**Subject: 1st Review Completion Letter
Koneru Short Plat, File No. SUB21-008
PACE Project No. 21436**

We are pleased to submit this letter and the accompanying documents in support of our proposed development of Koneru Short Plat. These submittal documents are provided in response to a review completion letter issued by City of Mercer Island on April 13, 2022. Review comments contained in that letter are provided below (plain text), along with a response (***bold italics***) indicating how each comment was addressed.

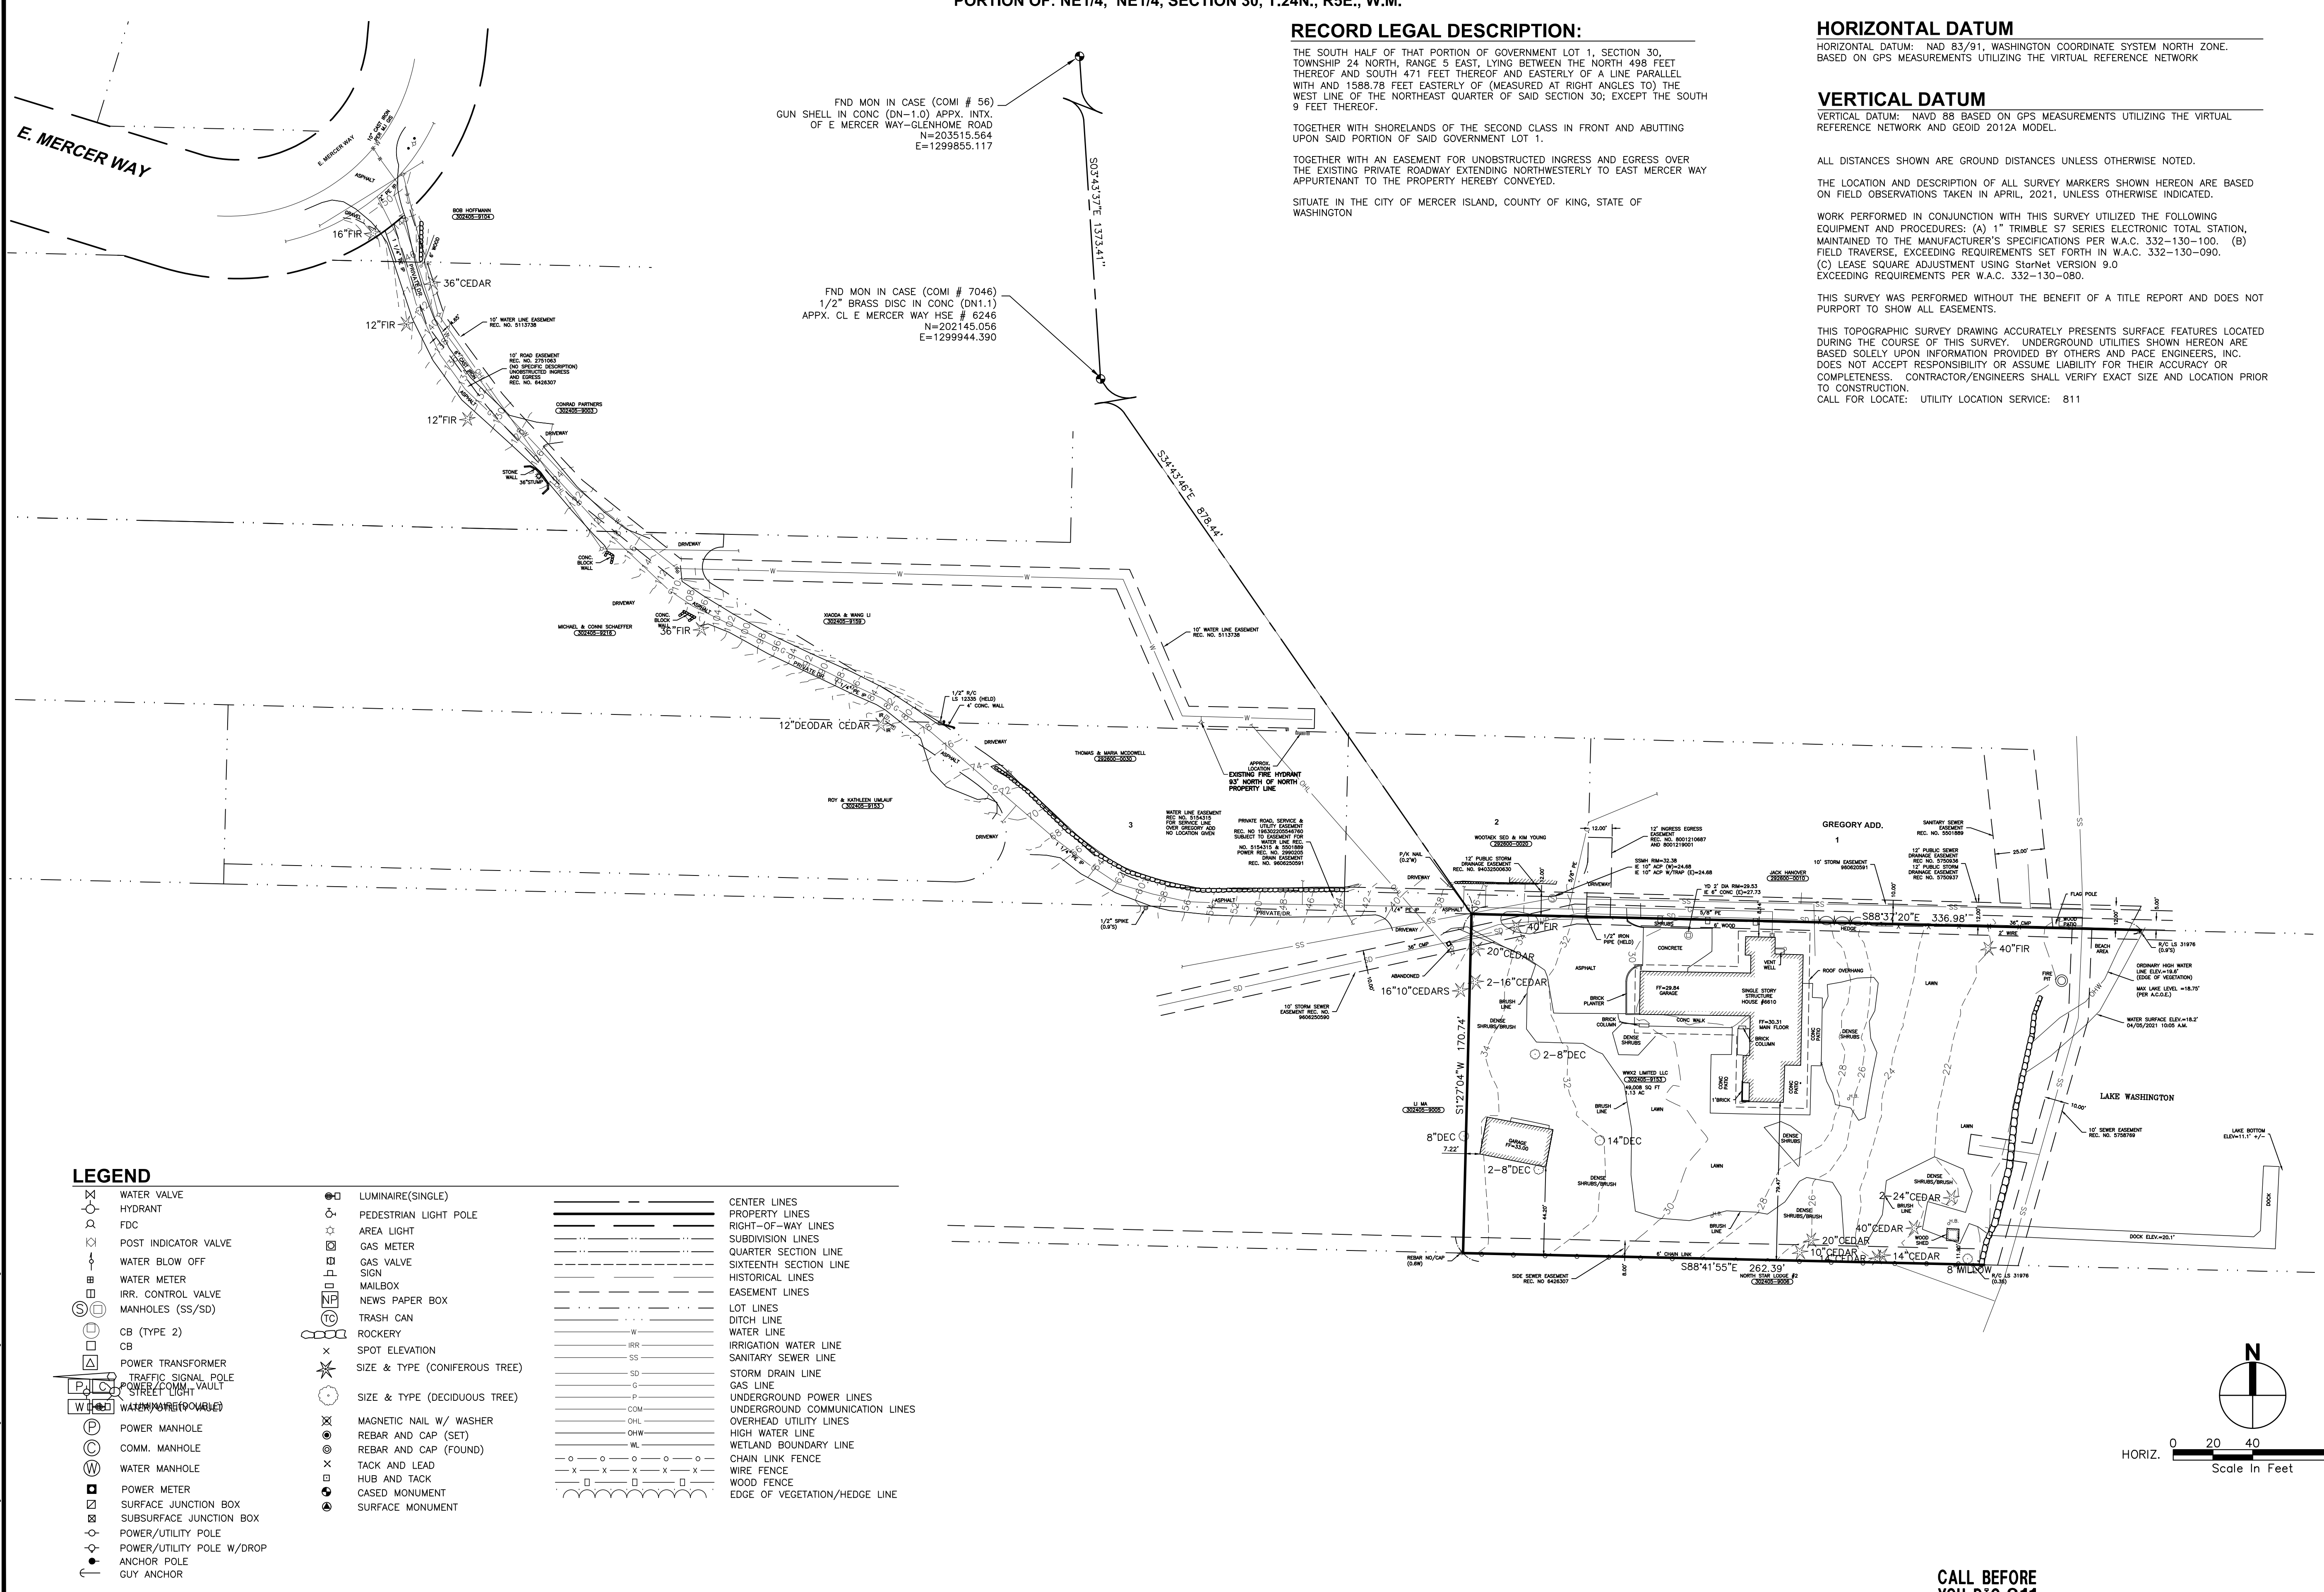
d. Topographic map: for any existing buildings, the map shall show the finished floor elevations of each floor of the building.

2. Tie this plat to at least two known city monuments on East Mercer Way.

PACE Response: Finished floor elevations have been added to the existing buildings on Sheet CO.1.

PACE Response: The Existing Conditions Sheet CO.1 has been updated to show the monuments used for control for this survey.

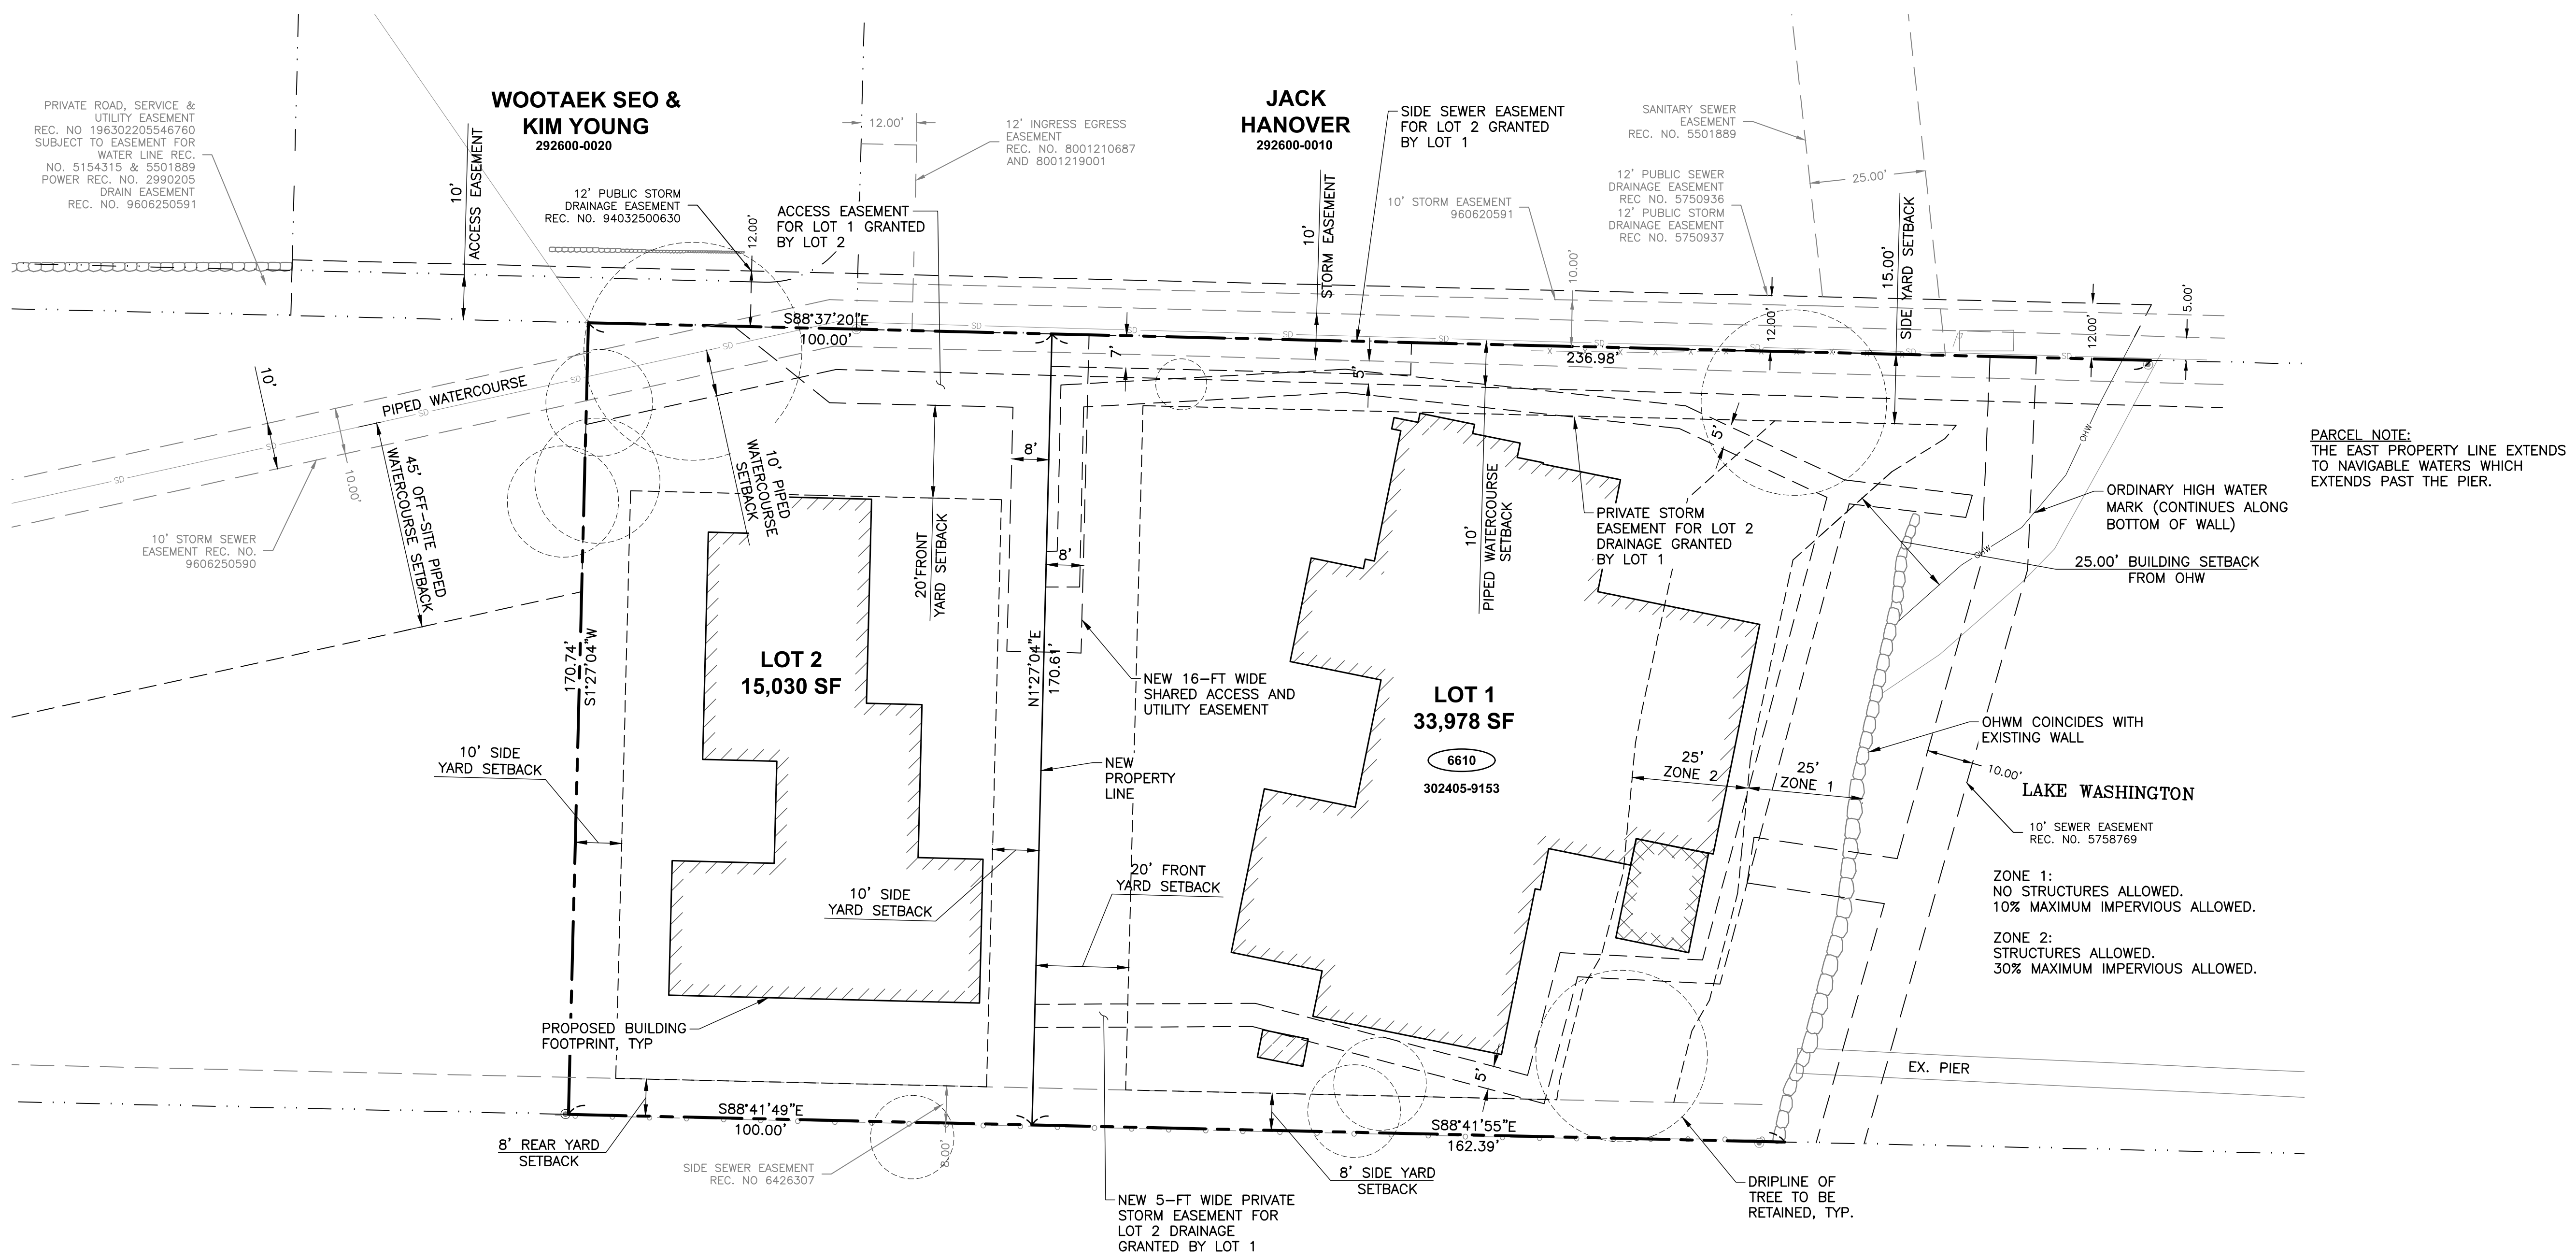
- j. Revise the following typos:
- i. Sheet C0.2: legal description misspells "said" in the second paragraph
 - ii. Sheet C1.0: piped watercourse note misspells "setback"

- k. Provide a table with the following information for the existing lot and Lots 1-2:
- i. Lot slope
 - ii. Maximum allowed lot coverage & hardscape
 - iii. Maximum allowed gross floor area (GFA)
 - iv. Net lot area
 - v. Lot coverage
 - vi. Hardscape
 - vii. Proposed lot coverage and hardscape*
 - viii. Gross floor area (GFA)*
 - ix. Lot width and depth
 - x. Parking stalls: covered and uncovered

PACE Response: The typos on Sheet C0.2 and C1.0 have been corrected.

PACE Response: The Zoning and Development Summary tables on C0.0 have been updated to include the requested information.

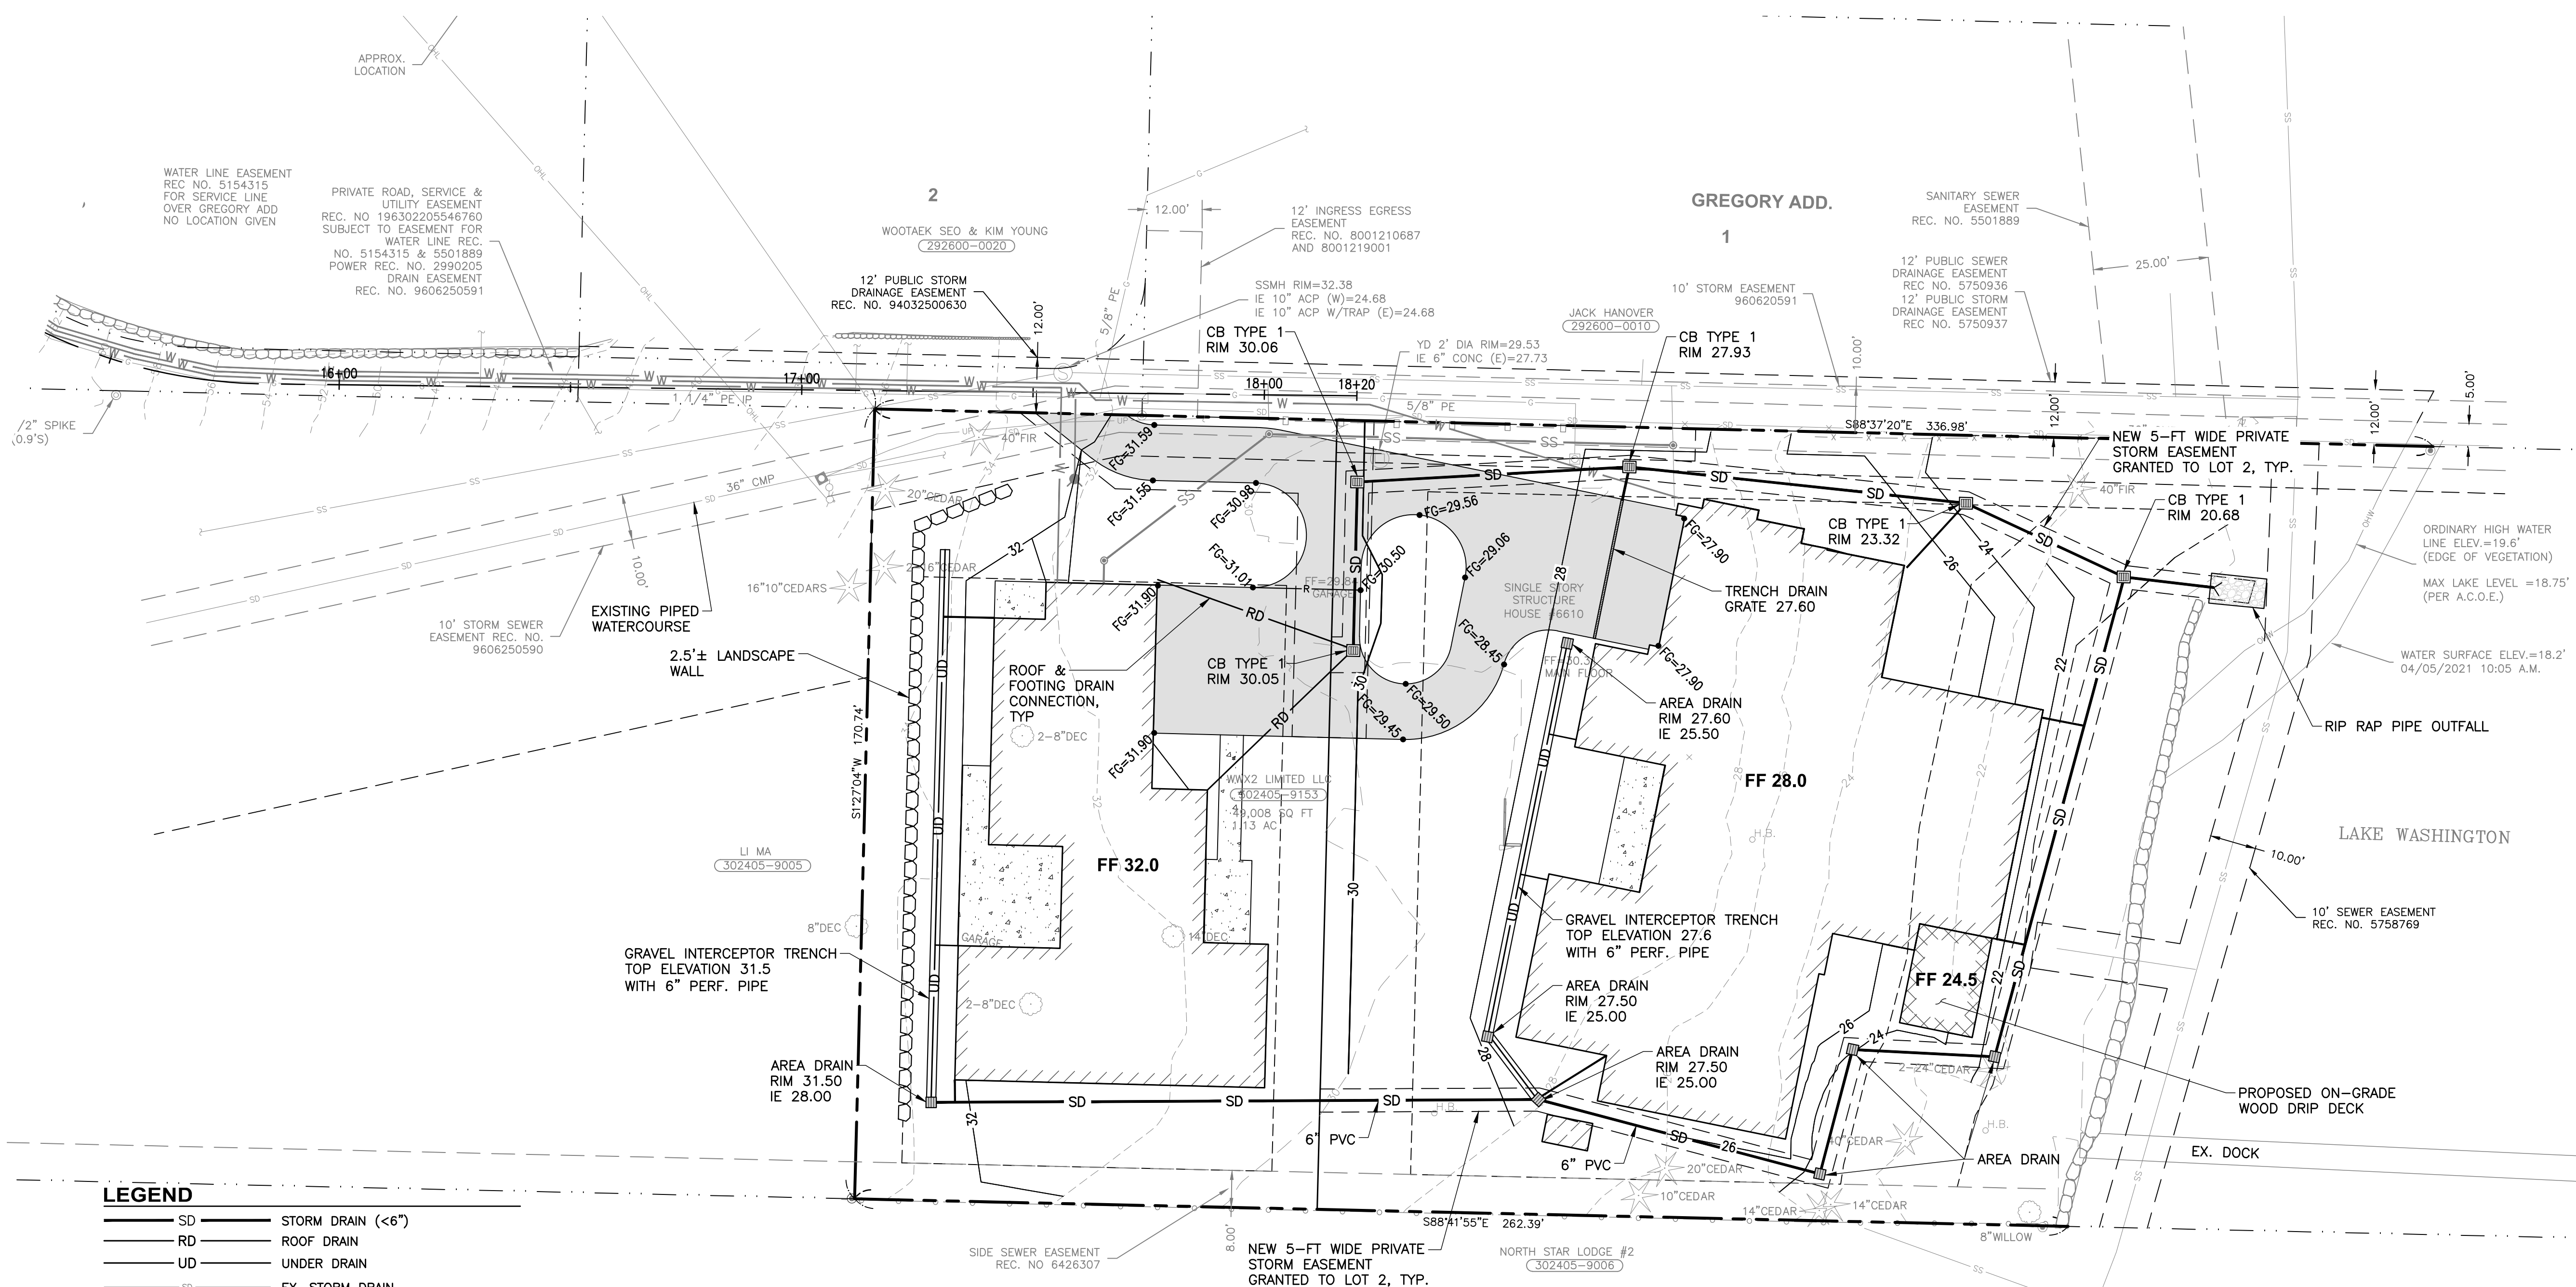
e. Note the Ordinary High Water Mark (OHWM) on Sheet C1.0. Refer to MICC 19.16 definition of “Ordinary High Water Mark.”

- b. For the portion of the piped watercourse off-site, revise the setback to be the standard 45 feet from the centerline of the piped watercourse. The setback reduction applies to the subject site only.

- c. Pursuant to MICC 19.07.180(C)(6)(d), lots with a width greater than 50 feet can reduce the piped watercourse setback to 10 feet when daylighting is determined by a qualified professional to result in one or more of the 4 outcomes listed under 19.07.180(C)(6)(d)(i-v). Please clearly illustrate and label the reduced 10-foot piped watercourse setback on Lot 1 and Lot 2.

d. Clearly illustrate and label the piped watercourse centerline. Piped watercourse is noted but it is unclear where it is located as there are multiple lines that look similar that represent existing easements. Please use a different line to represent the piped watercourse and add an arrow.

e. Revise the 10' watercourse setback to "10' piped watercourse setback."

PACE Response: The Ordinary High Water Mark shown on the plans is the surveyed vegetation line with an elevation of 19.6 and continues along the base of wall. MICC 19.16 notes the Ordinary High Water Mark is a “mark upon the soil a character distinct from that of the abutting upland”, which is what the survey crew located. According to MICC 19.16 an elevation of 18.6 (NAVD 88) can be used for the OHWM for establishment of building setback lines. Since the surveyed OHWM line at elevation 19.6 is higher than 18.6, setbacks measured from the survey line exceed what is required MICC 19.16.

PACE Response: The setback from the piped watercourse has been shown as 45-ft offsite as noted.

PACE Response: 10-ft piped watercourse setback on Lot 1 and Lot 2 has been called out on Sheet C1.0.

PACE Response: The entire piped watercourse has been updated to the "SD" line type and has been called out on Sheets C1.0 and C3.0.

PACE Response: Dimension callout on Sheet C1.0 has been revised accordingly.
